**WEST SUSSEX COUNTY COUNCIL
STRATEGIC PLANNING CONSULTATION**

SUBJECT: LU/161/14/PL - Proposed Light Industrial development

LOCATION: Fort Road Garage, Fort Road East, Littlehampton, West Sussex, BN17 7QZ

**AMENDED INFORMATION RECEIVED – AMENDED OWNERSHIP CERTIFICATE AND
LOCATION AND BLOCK PLANS.**

Site plan 1:200

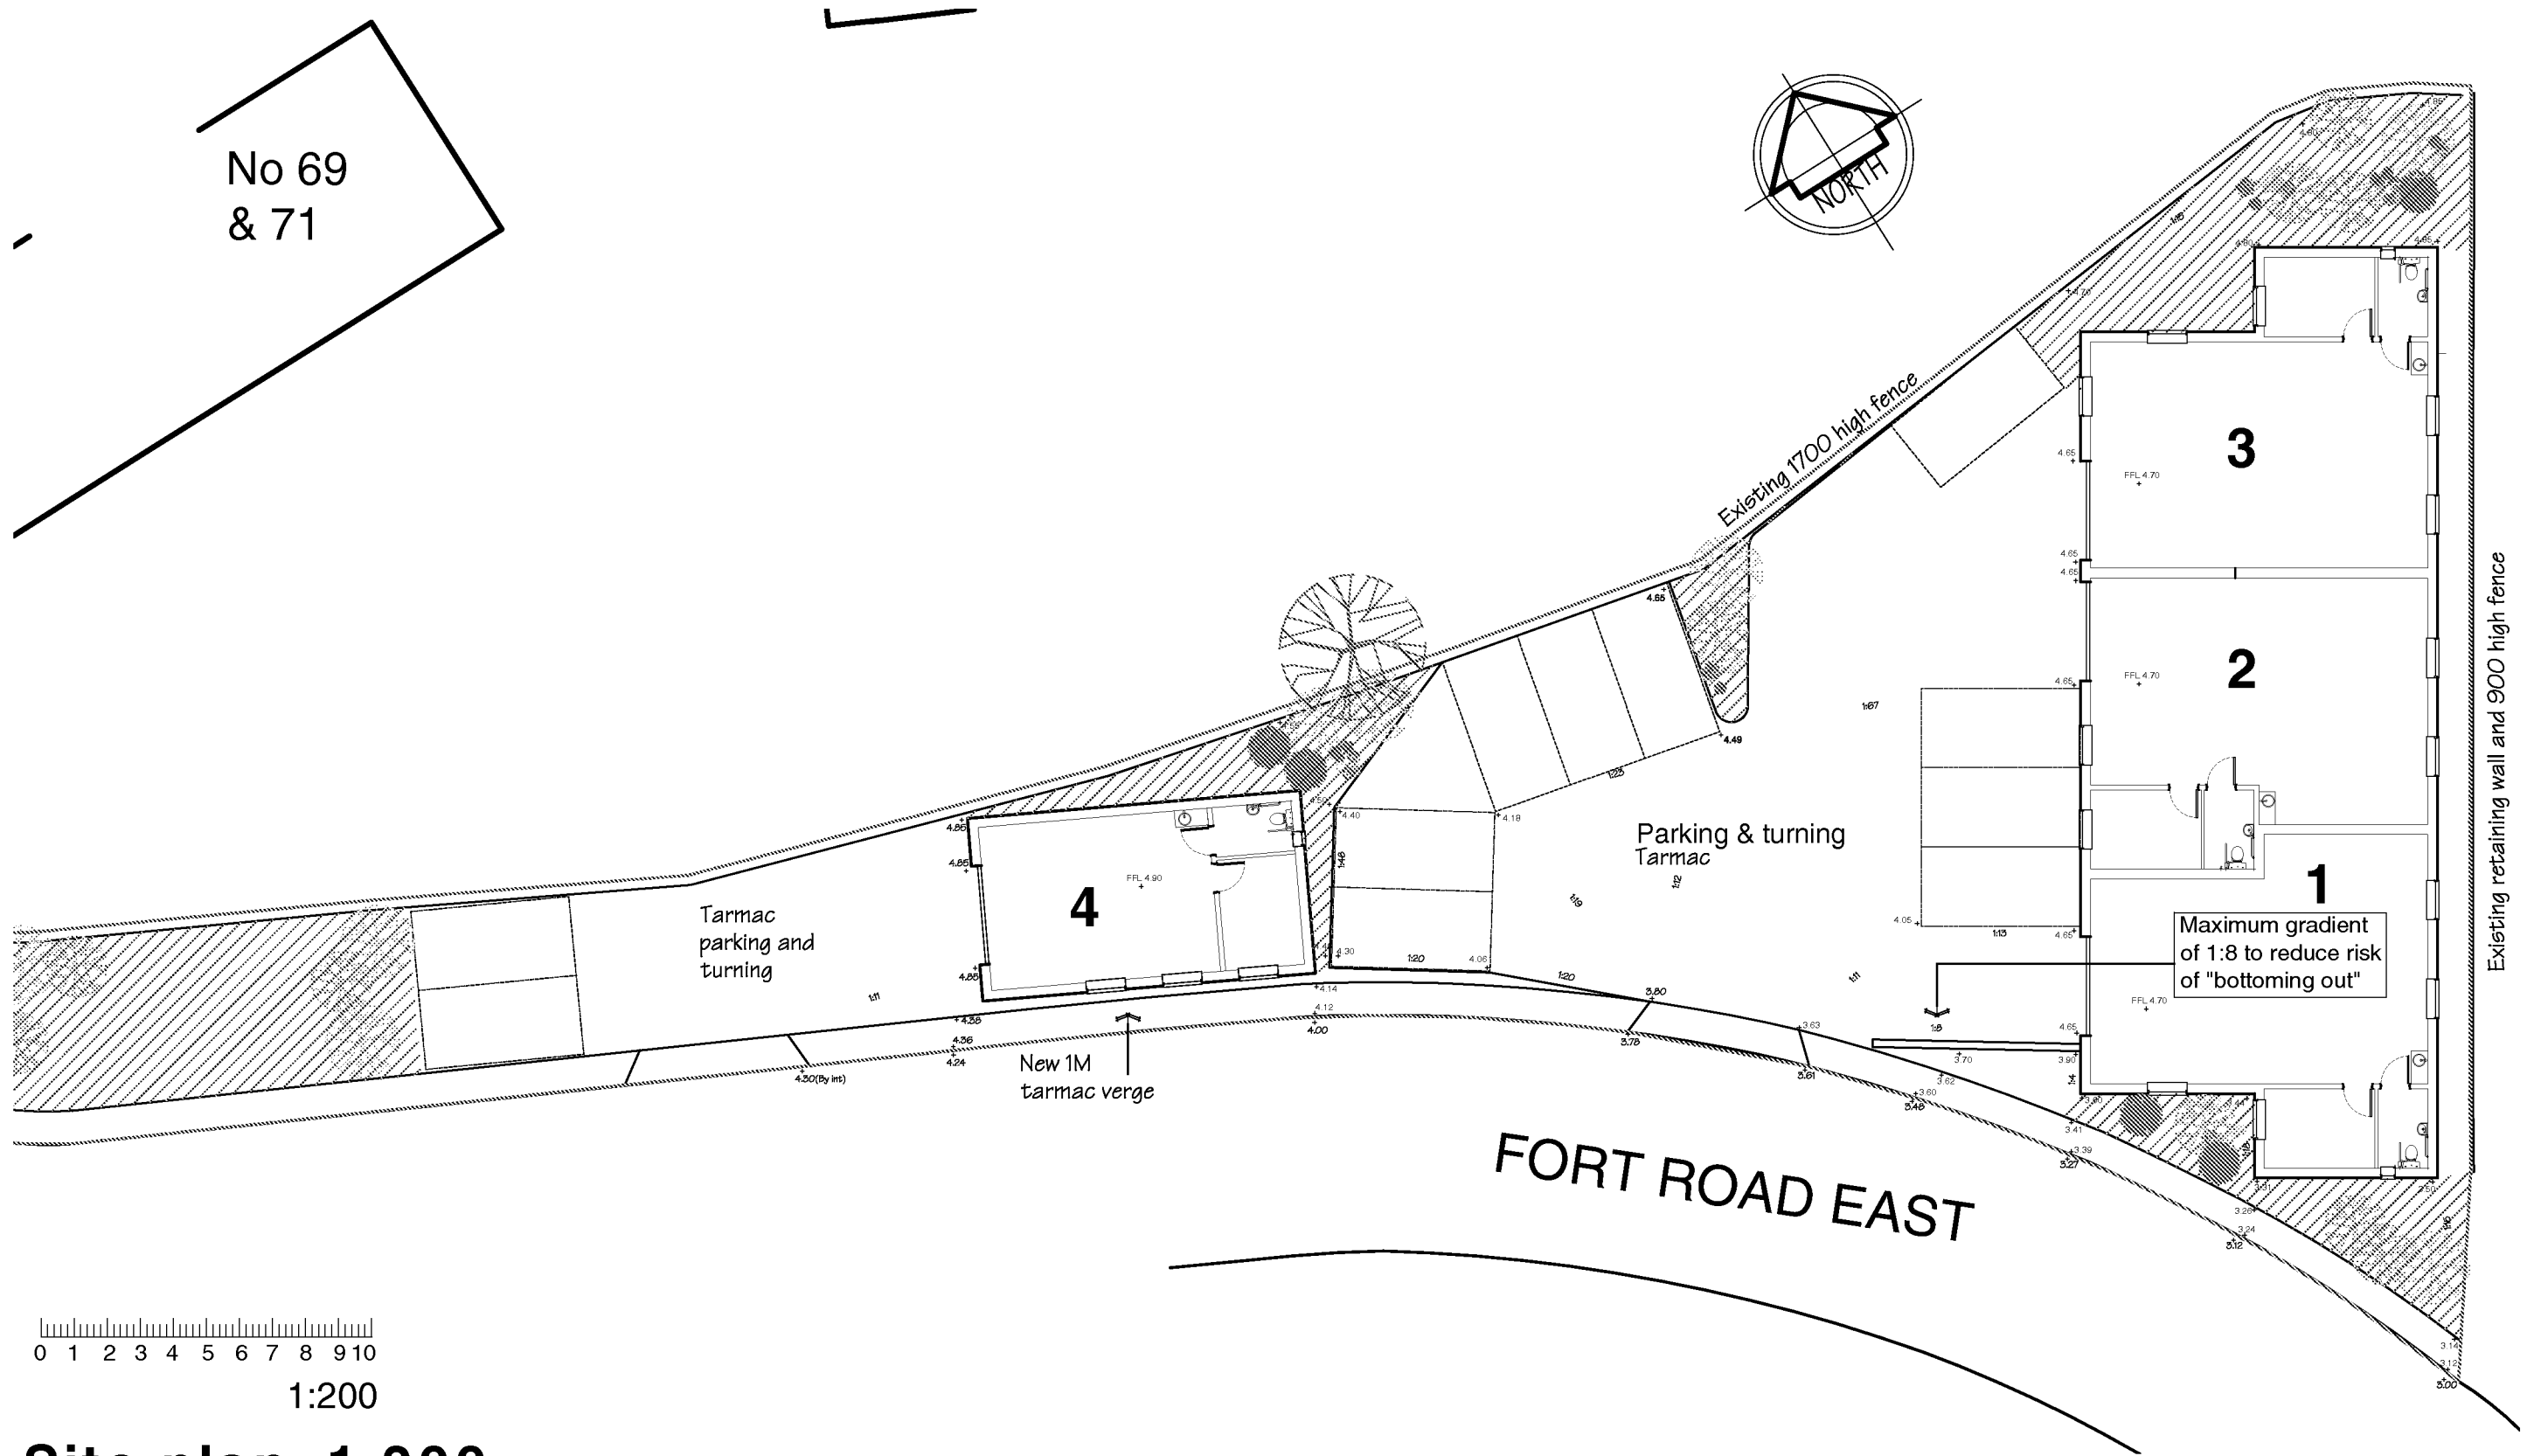
1. A 1.8m wide footway along the entire site frontage, connecting with Fort Road (to the west) – including provision to cross Fort Road East at an appropriate point along the site frontage corresponding with a crossing point on the south side of Fort Road East (red edging to be extended around this and sight lines to be shown at the crossing point).
2. A Stage 1 Road Safety Audit and Designer's Response for the footway and access points.
3. Visibility splays (including pedestrian splays) at each access point commensurate with the speed limit on Fort Road East.
4. Revised parking and building layout to reflect changes to site frontage brought about by new footway.
5. Secure and covered cycle parking to be shown on-site.
6. A Travel Plan Statement to be provided.
